KITITAS COUNTY

MEMORANDUM

TO: Community Development Services
FROM: Public Works Plan Review Team
DATE: November 23, 2021
SUBJECT: SE-21-00027 Fish Food Bank Warehouse Expansion

Public Works Pre-Application Comments

OVERALLSITEPLAN

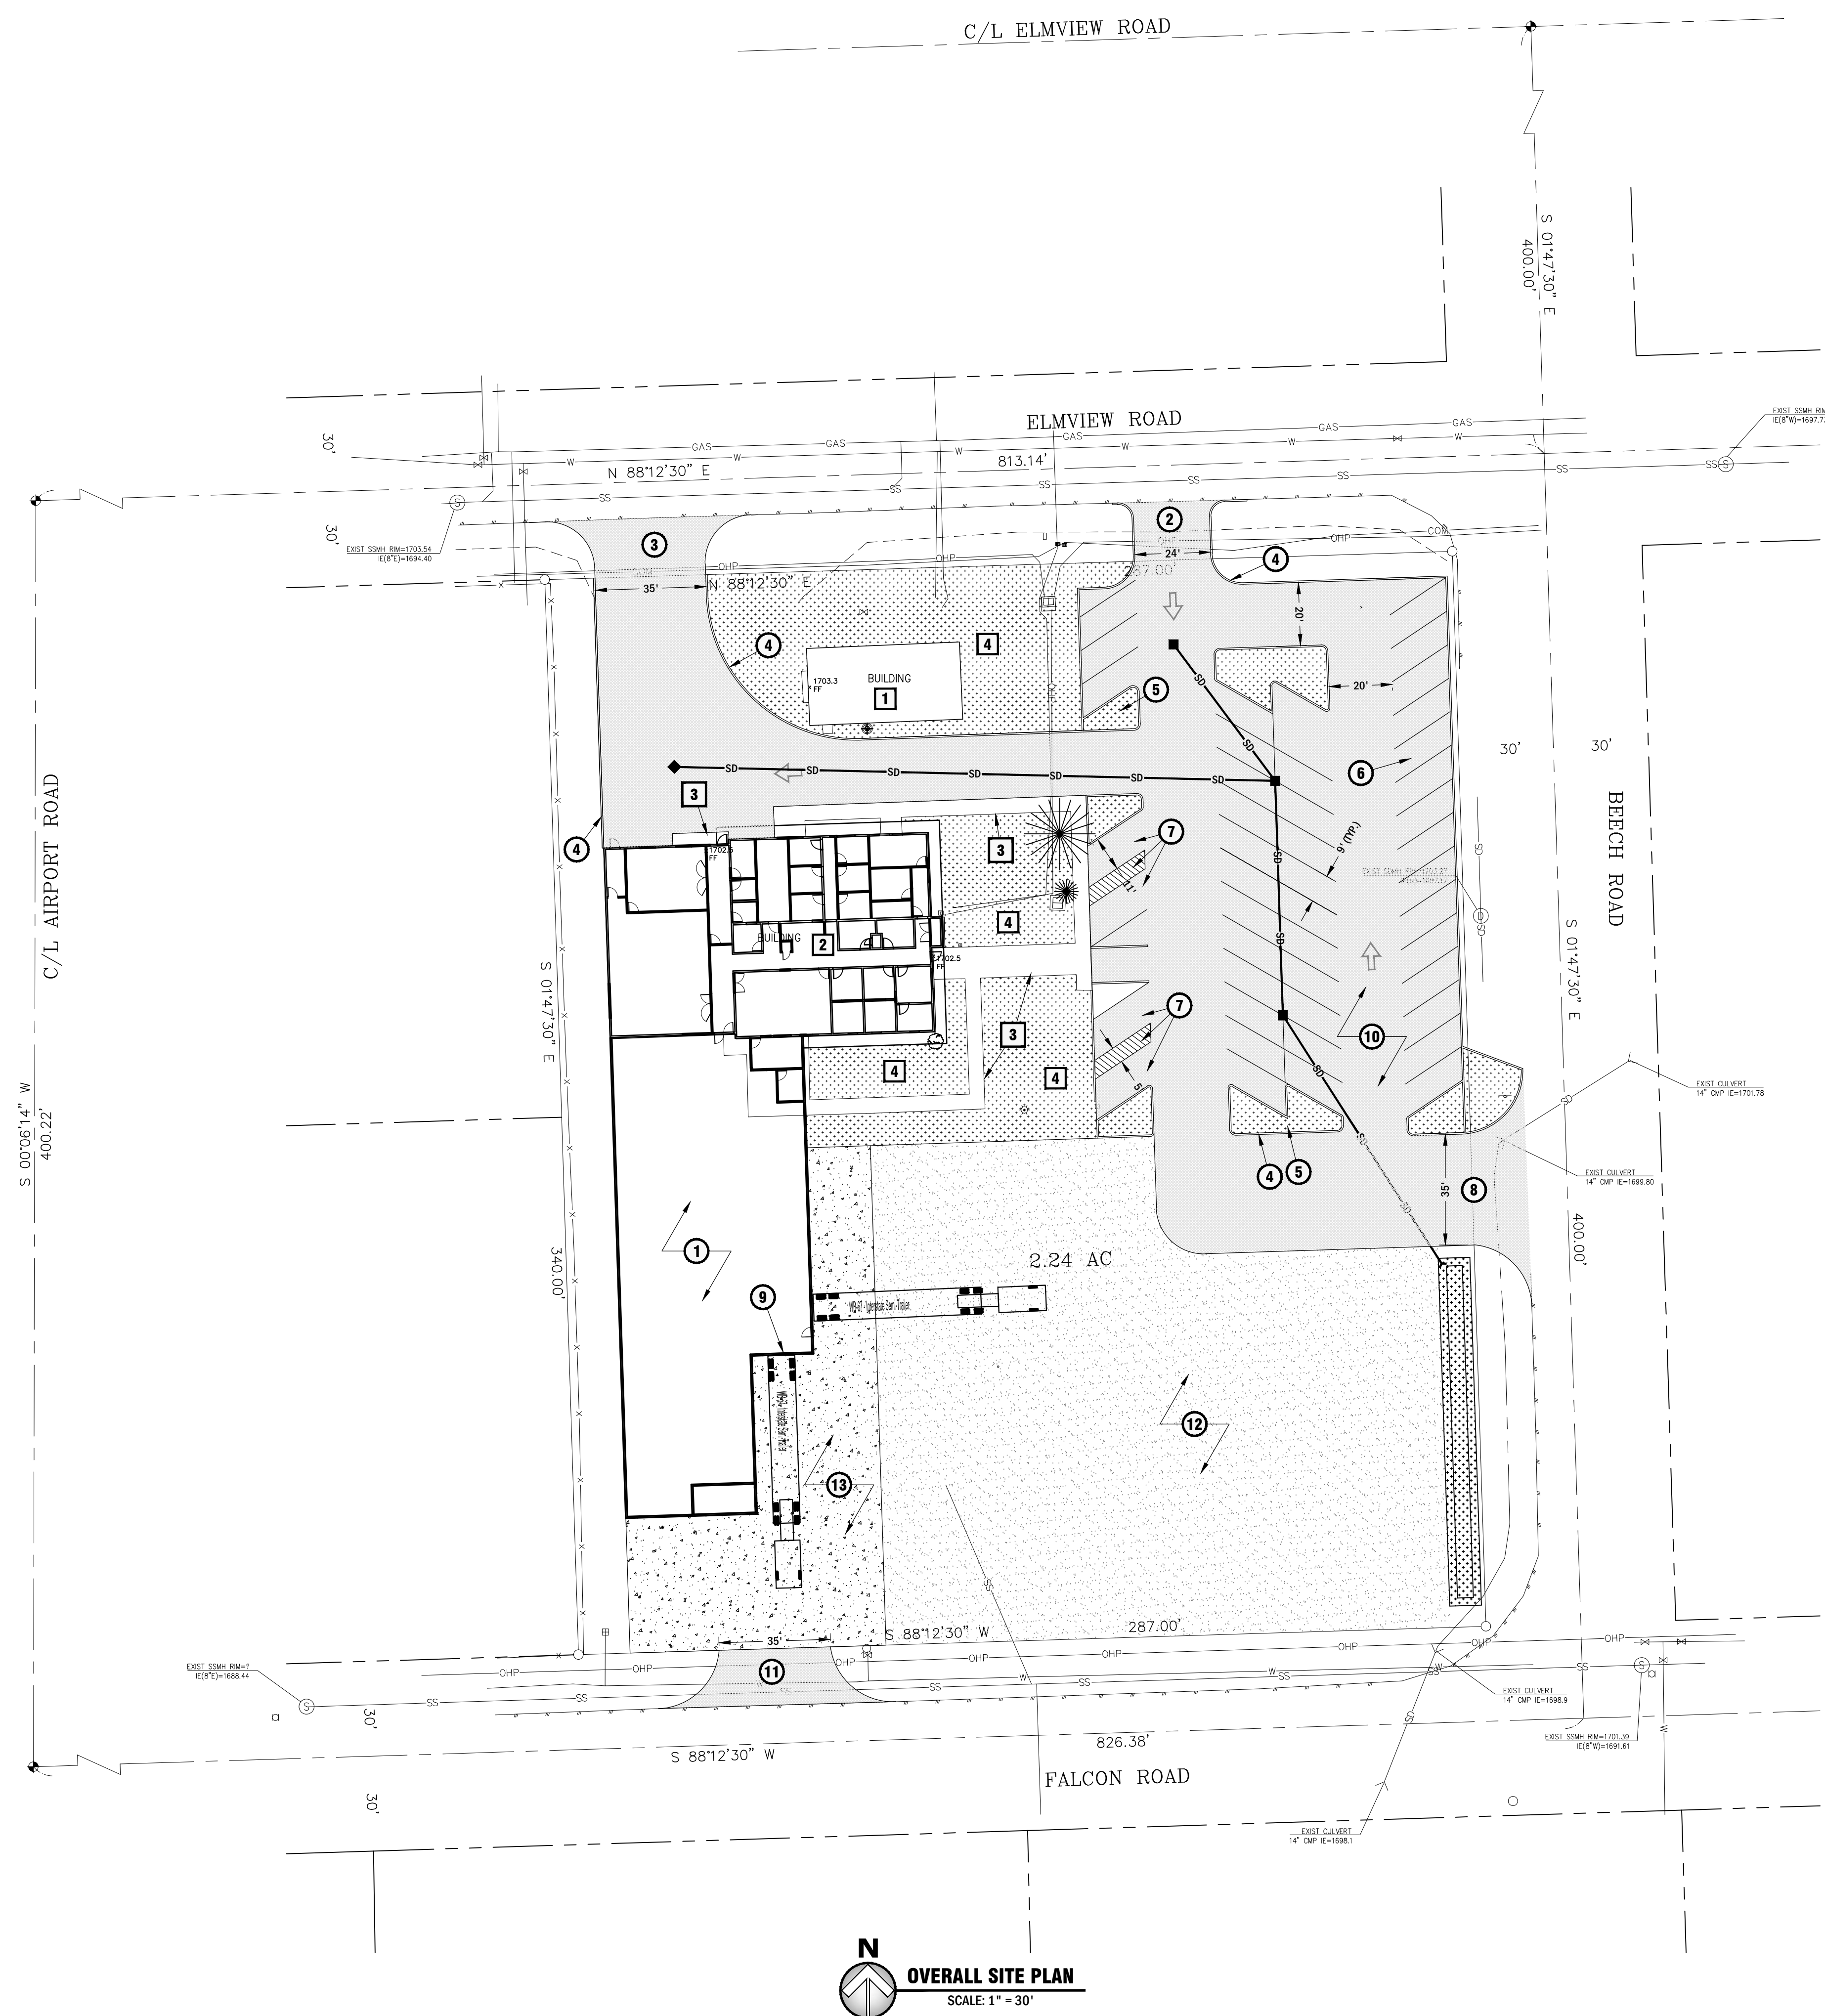
- An access permit will be required for the changes in access. All accesses shall meet Kittitas County Code spacing requirements.

Please note: Only one access will be allowed per street as discussed in the pre-app meeting and further review. The recent plan set shows 2 accesses on Elmview Rd. The eastern entrance on Elmview would create issues with number of accesses and access spacing to the intersection.

- Any commercial access will require a paved apron constructed to Kittitas County Private Road Standards. Please contact Public Works for design requirements and questions.
